Application by Cottam Solar Project Limited (“the Applicant”) for an Order granting Development Consent for the proposed Cottam Solar Project (“the Proposed Development”).

Thank for providing West Lindsey District Council (WLDC) the opportunity to comment on the amended application documents submitted in connection with the above application.

Figure 8.16.5: Landscape and Ecology Mitigation and Enhancement Plan – Cottam 1 South (Sheet 2) Revision A

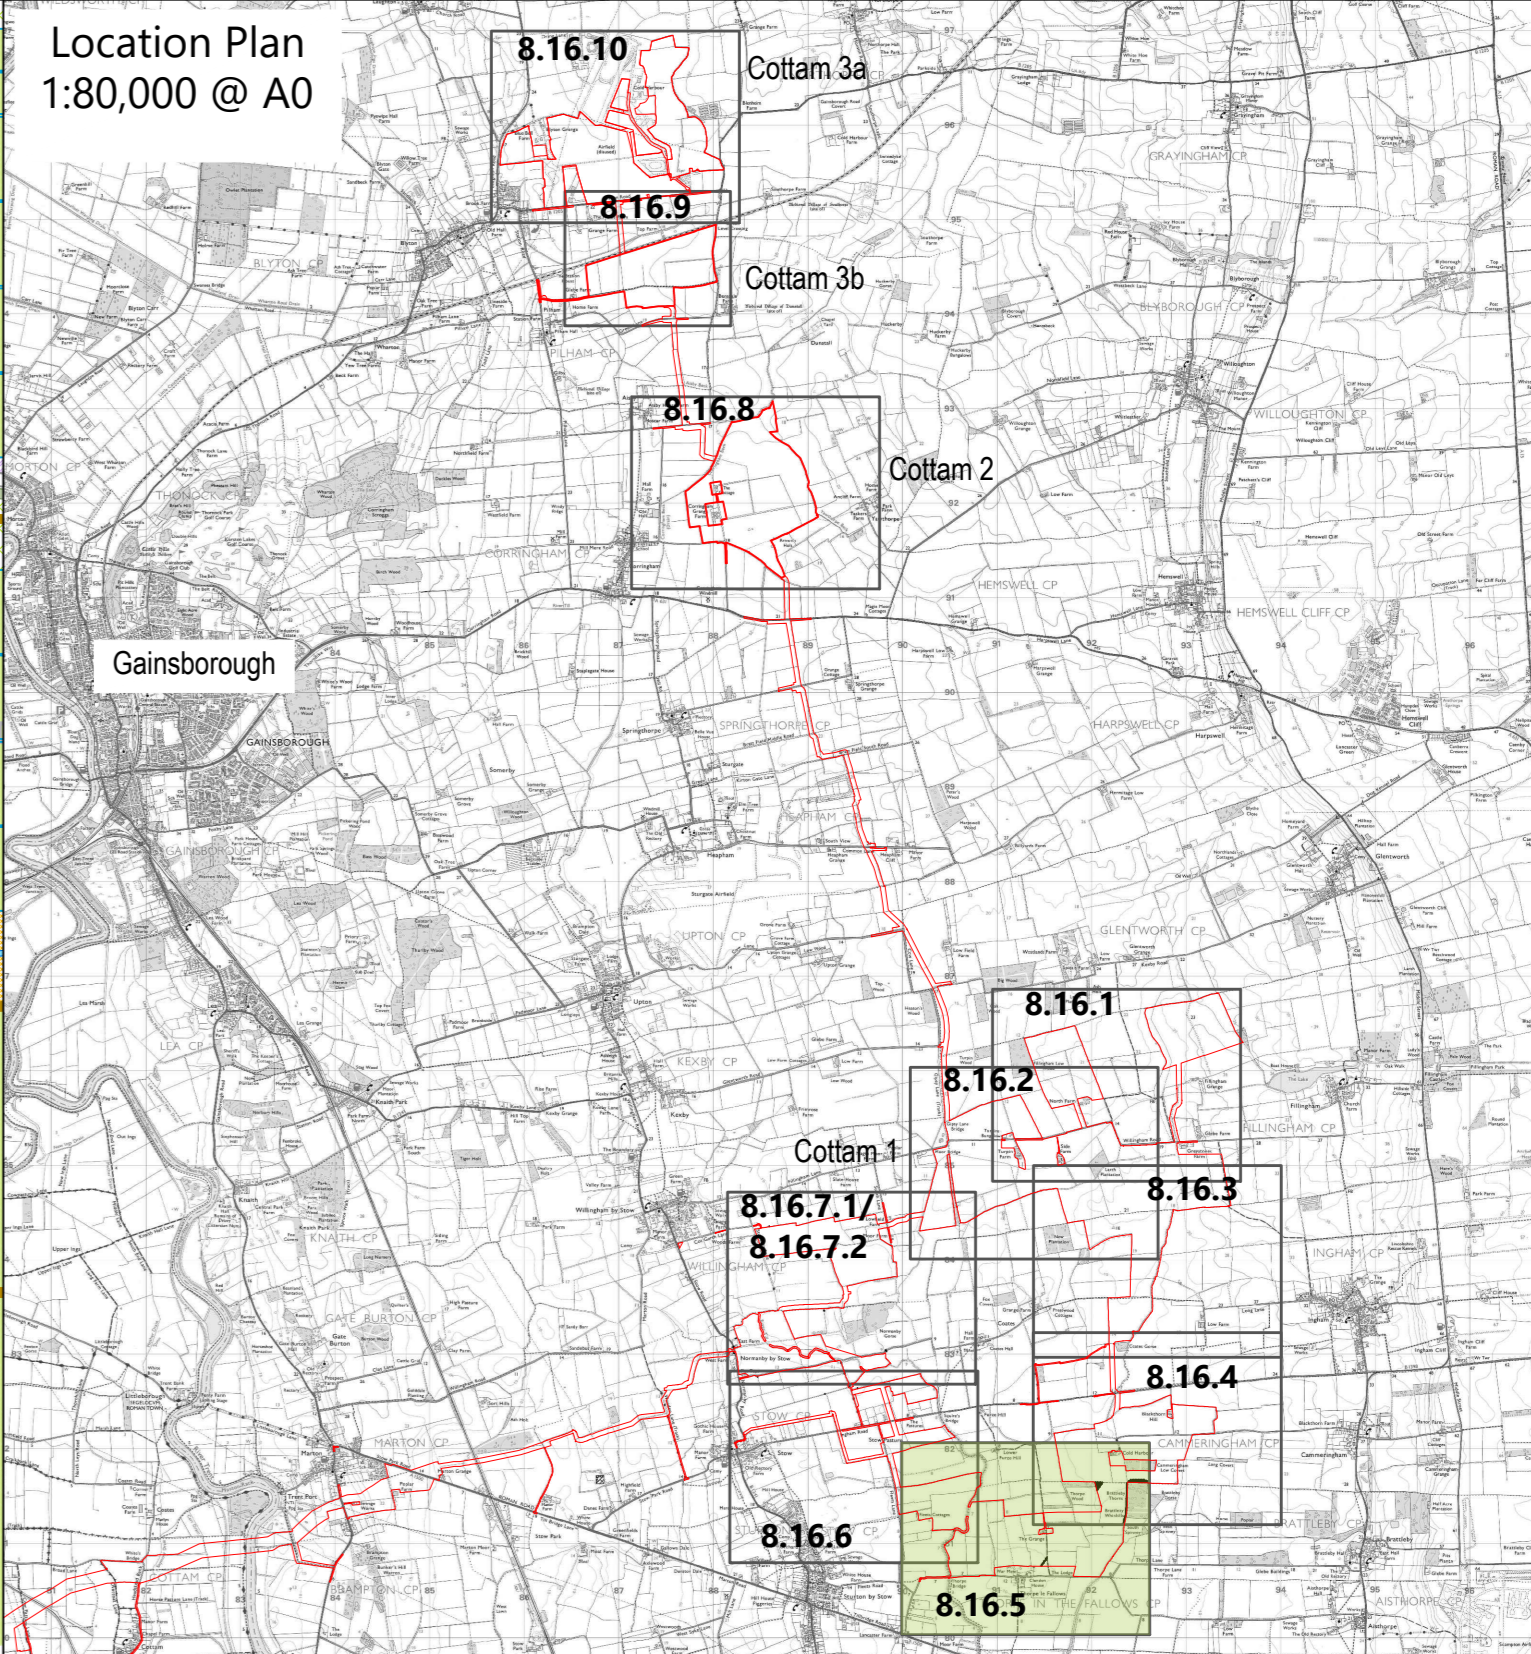
Work Number 7A relates to a range of development that could readily require mitigation to ensure the impacts of the scheme are acceptable (e.g. boundary treatments, lighting, access tracks, earthworks, acoustic barriers and construction laydown areas). WLDC remains unclear as to why such works are required in the area and why they remain authorised in the draft Development Consent Order (DCO). WLDC recognises the amendments made to the outline LEMP (Rev F) and Figure 8.16.5 ‘Cottam South (Sheet 2)’ which shows the proposed use of the land in question. On the basis that the above

Works will be retained, WLDC would expect the area to be avoided by development as far as possible and would seek control through the LEMP when approving subsequent details.
